Recommendation Report for Planning Permission

REF NO: R/230/19/PL

LOCATION: Springfield House
Springfield Close
Rustington
BN16 2SZ

PROPOSAL: 1 No. dwelling and swimming pool (part resubmission following R/91/17/PL & R/204/18/PL).

FIRST FLOOR PLAN

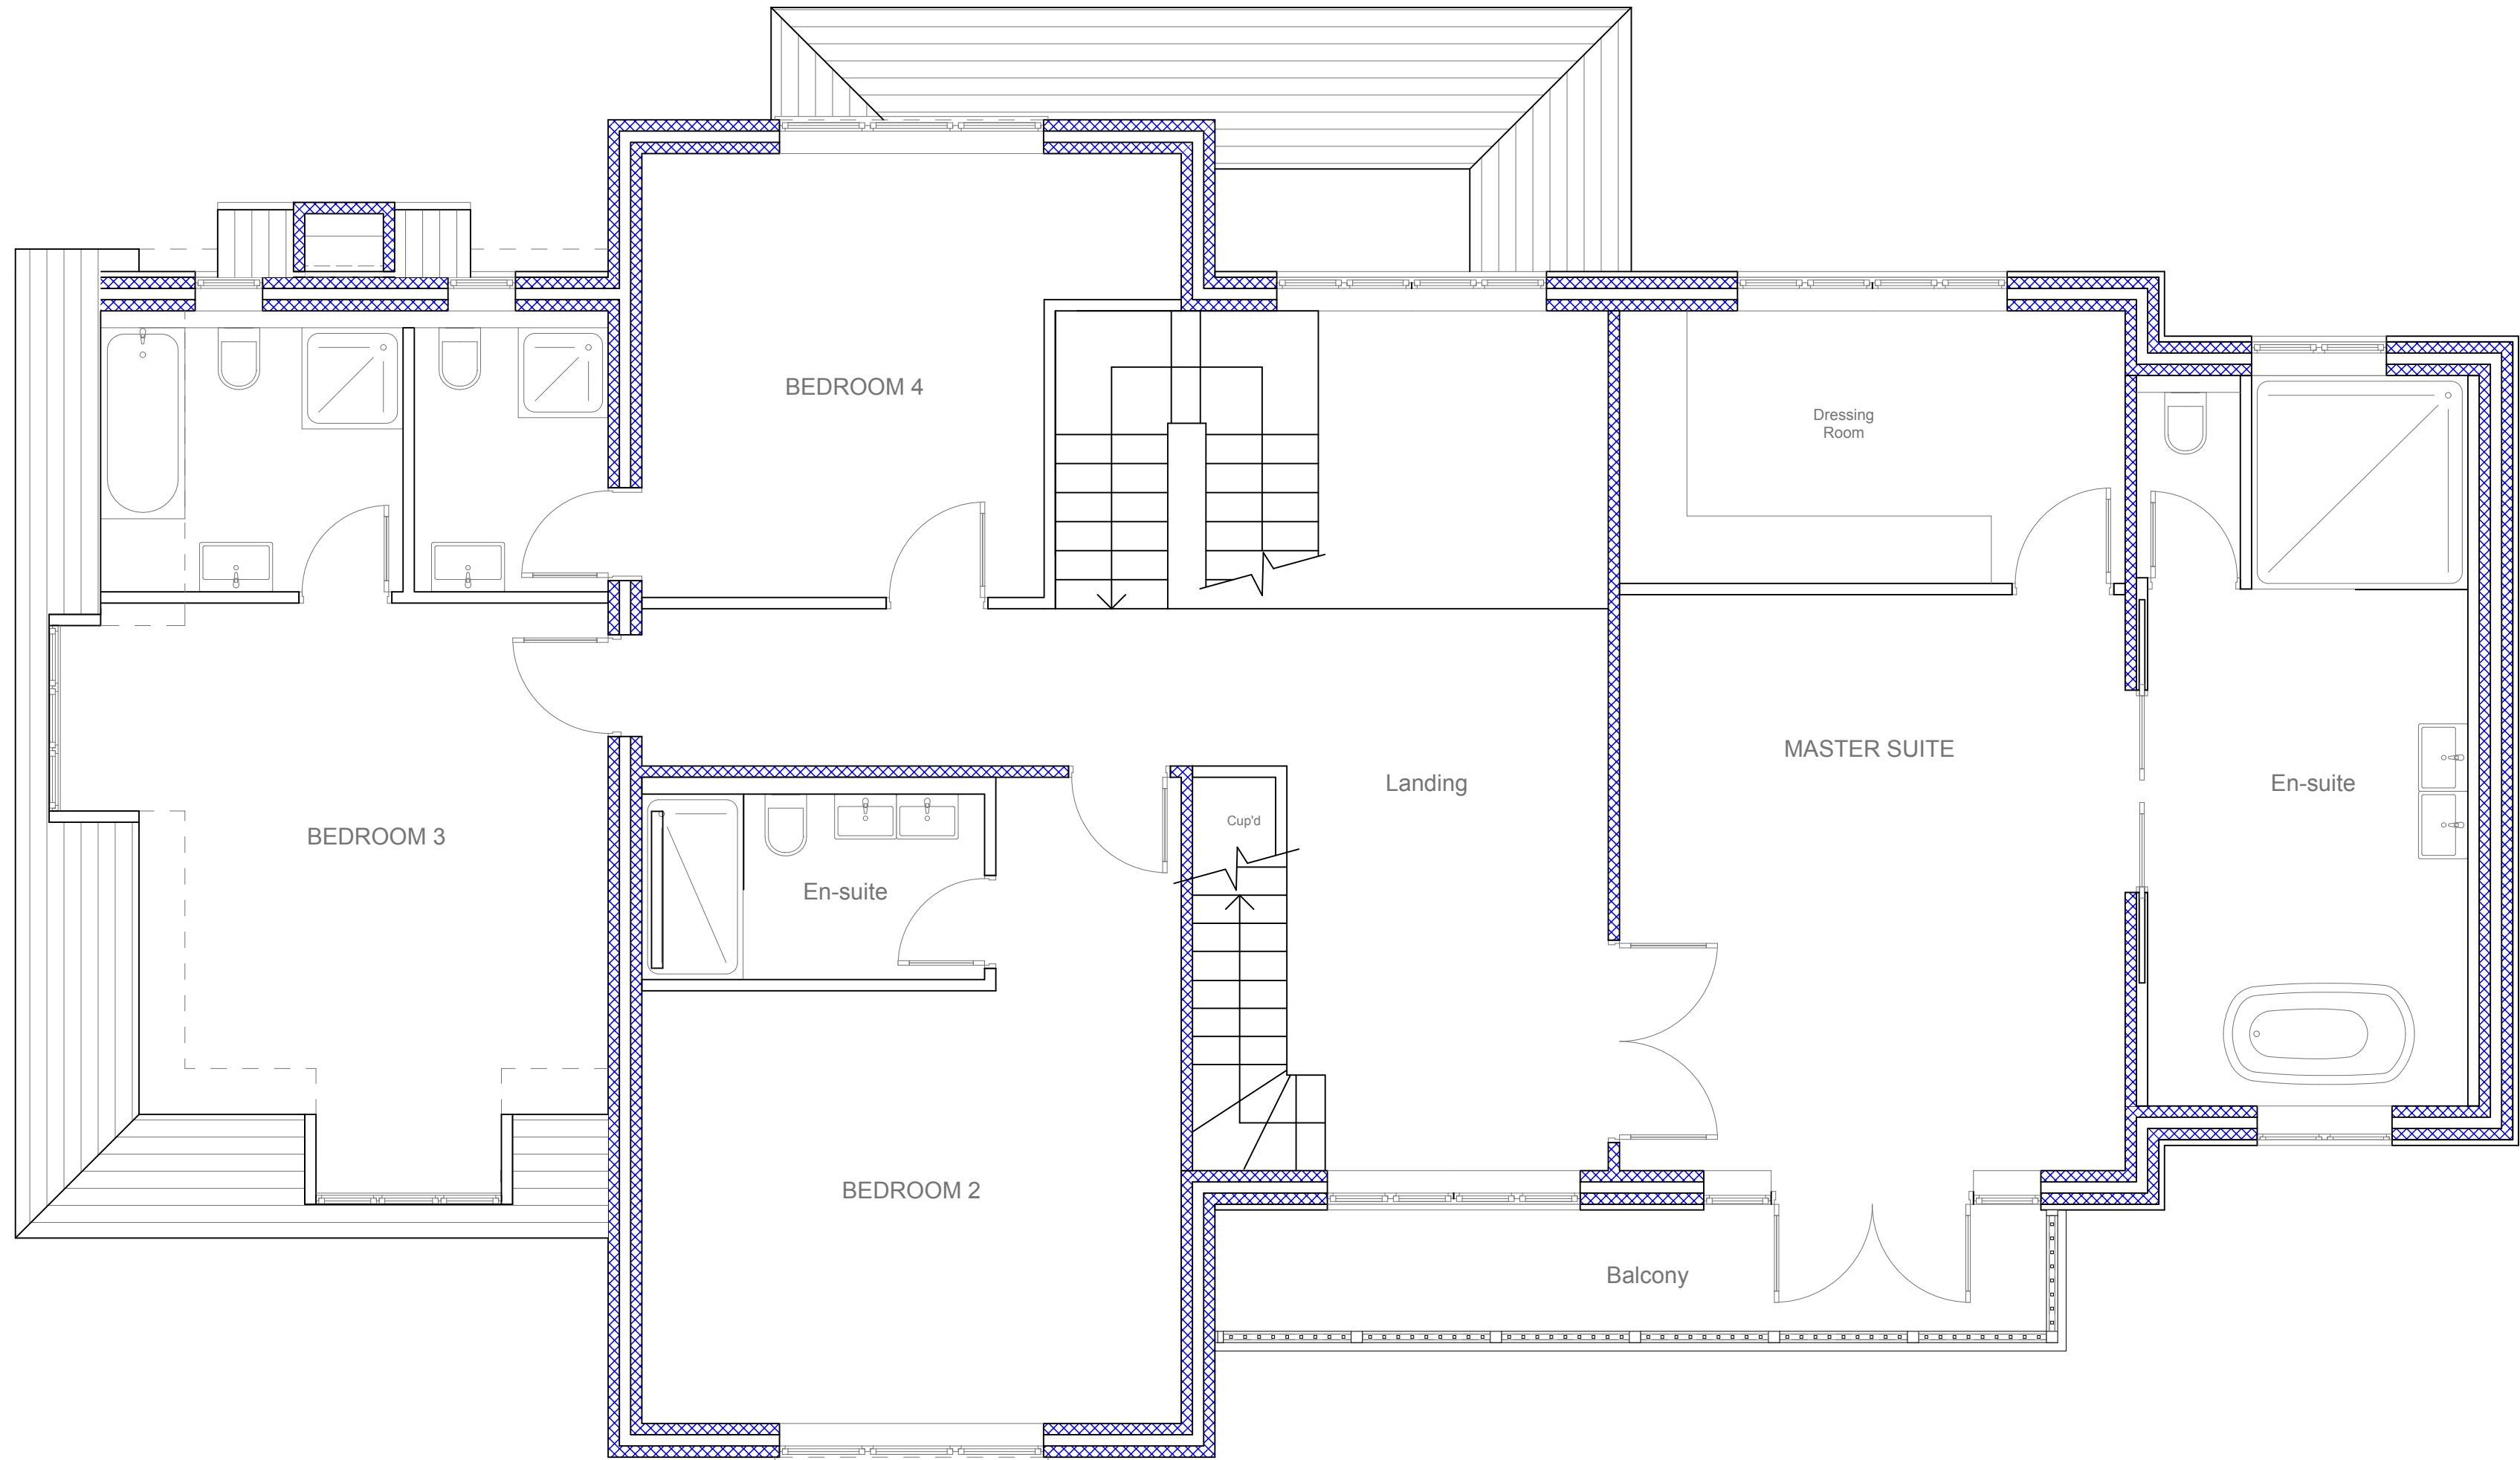
- South facing balcony, pool and enlarged paved area will only serve to negatively impact all surrounding properties.
- Can't read all objection letters

In terms of the design changes the fenestration alterations, including the addition of further roof lights are not considered to significantly change the appearance of the approved dwelling which fully responds to the context of the site, reflecting the architectural styles and massing of nearby properties as well as using high quality materials consistent with the local context. The fenestration changes do not significantly alter the appearance of the building. The addition of further roof lights reflects the principle of second floor openings established in the existing dwelling.

SECOND FLOOR PLAN

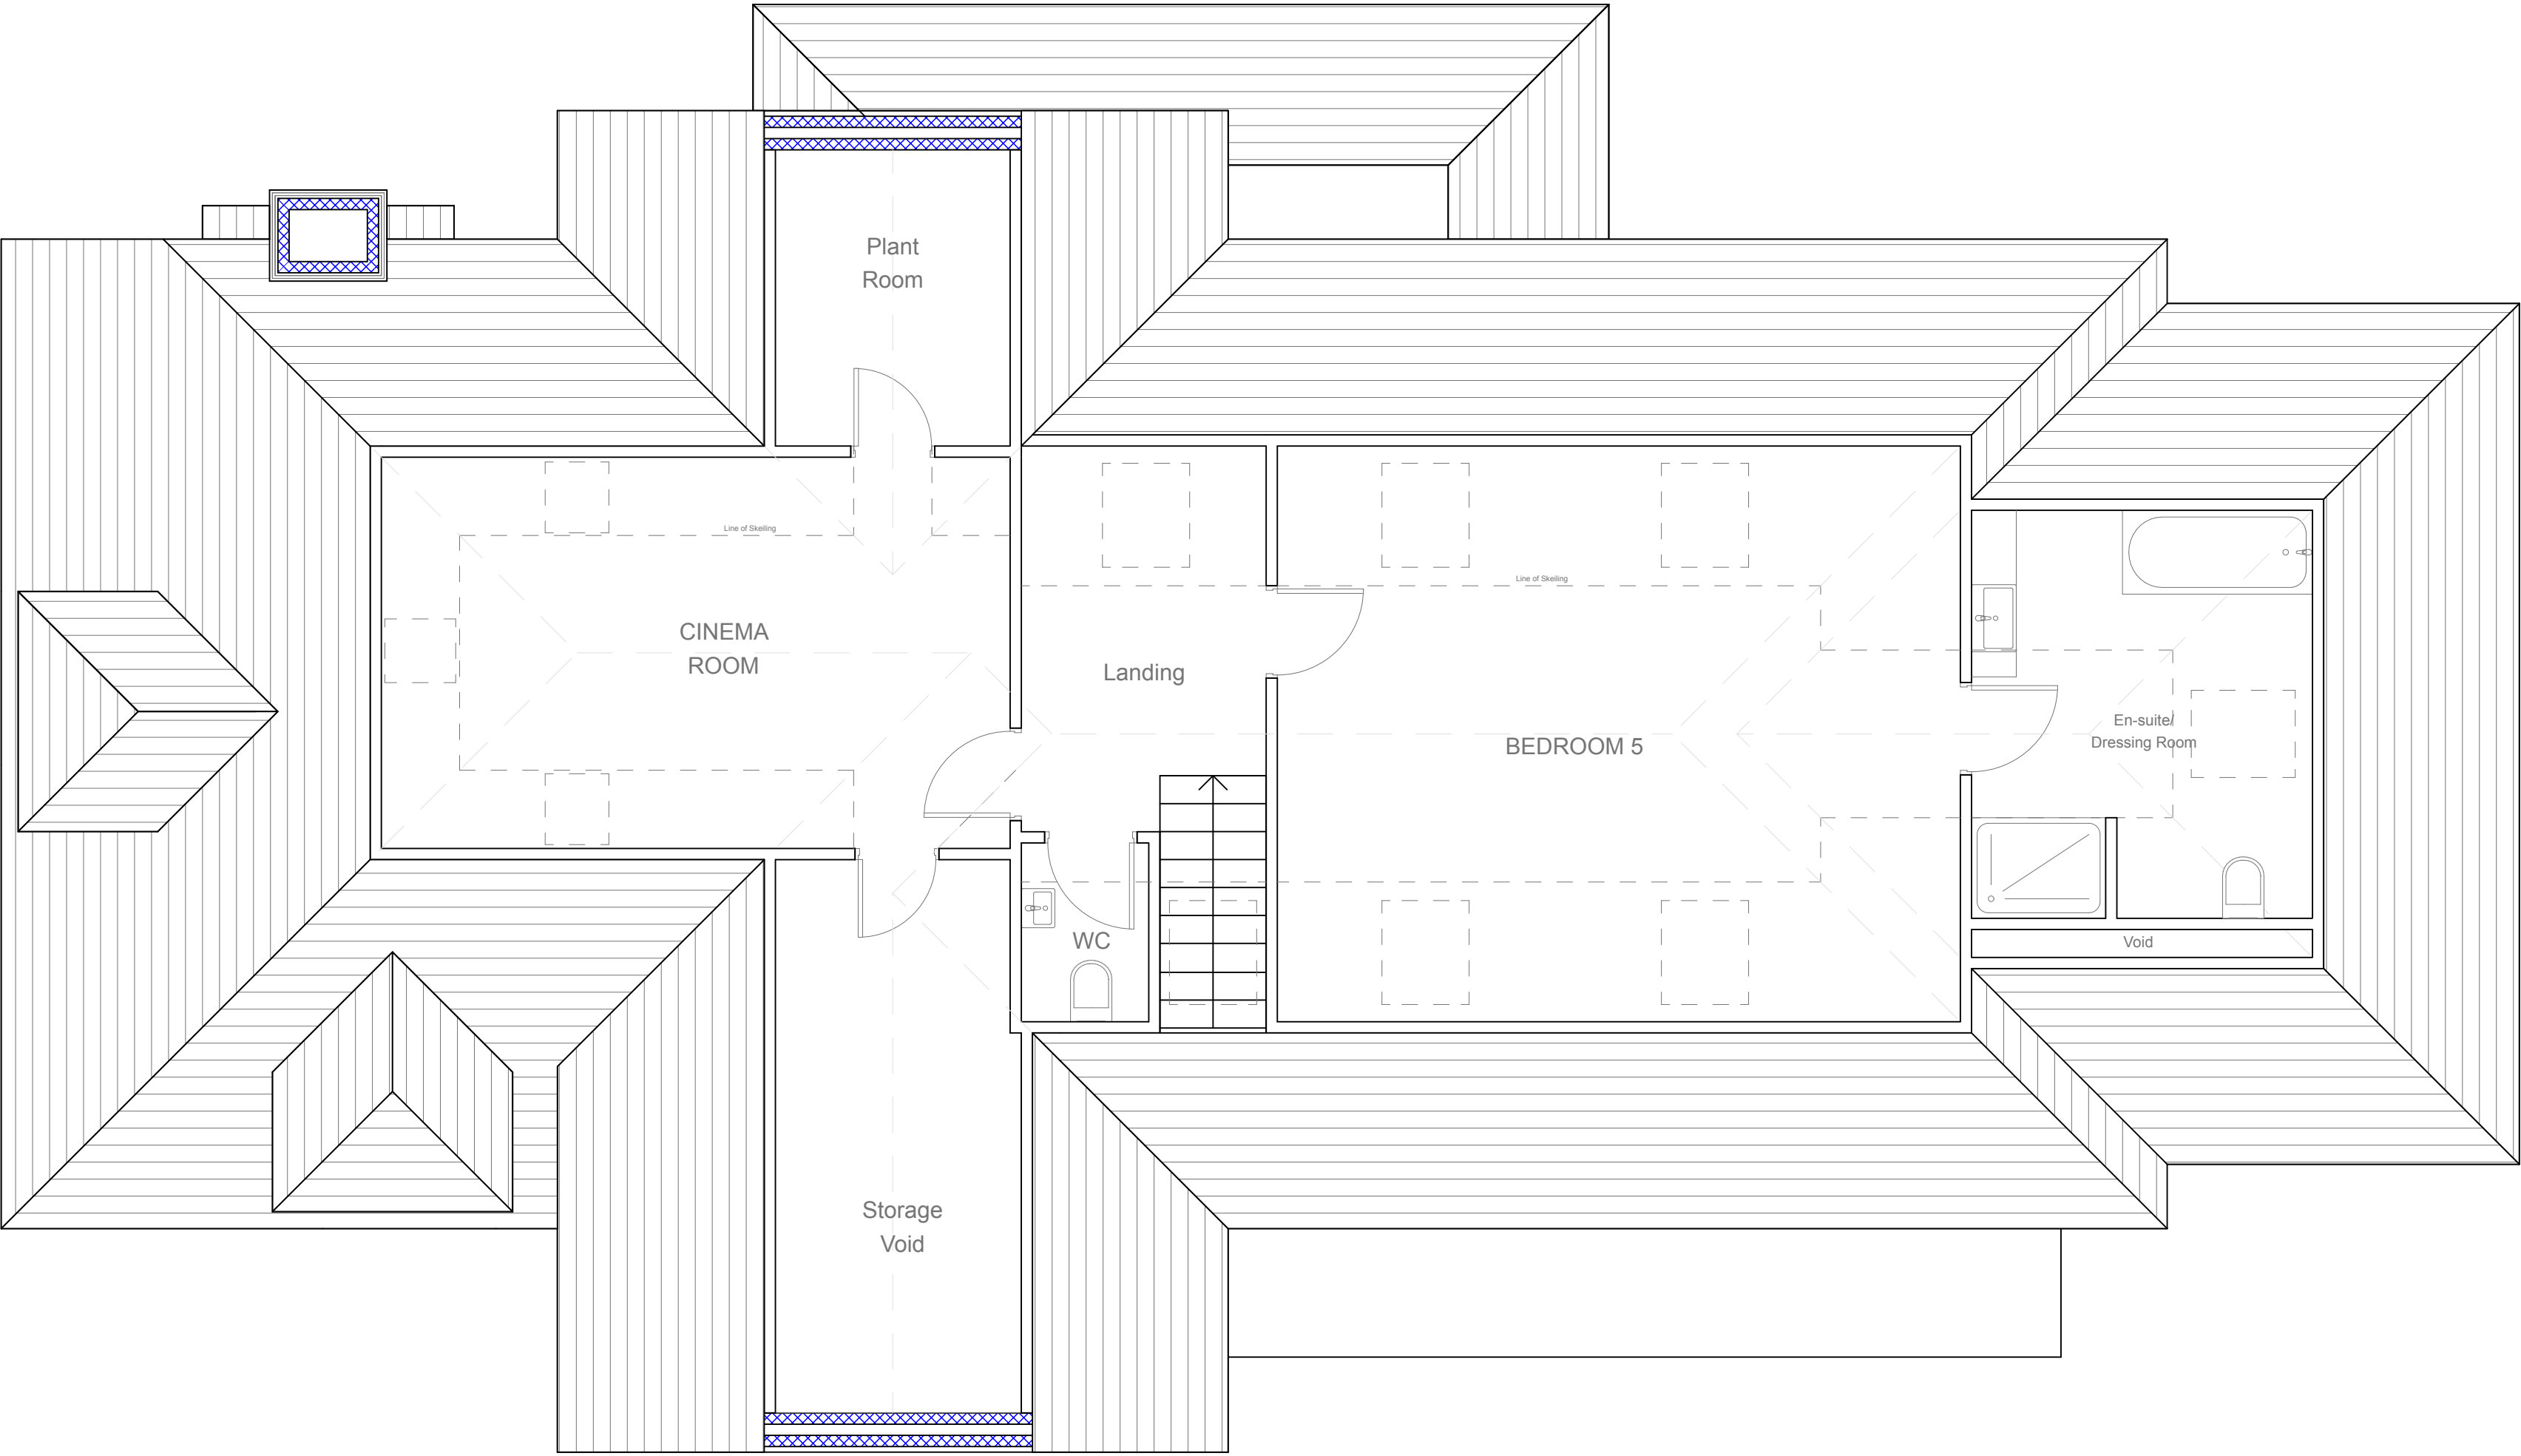
- The pool would create nuisance to 7 -8 properties by users and pumps.
- Changes to the western aspect mean the 'plant room' is now renamed and has a dormer with a view directly into neighbouring property. We note the windows to the eastern aspect are to be frosted glass and would request the same to the westerly aspect if the trees are to be removed. This will help mitigate the negative impact of this imposing development.

The roof light windows on the western elevation is 13.5m from the side boundary and 16m from the nearest rear garden which is an adequate distance to preclude adverse over looking.
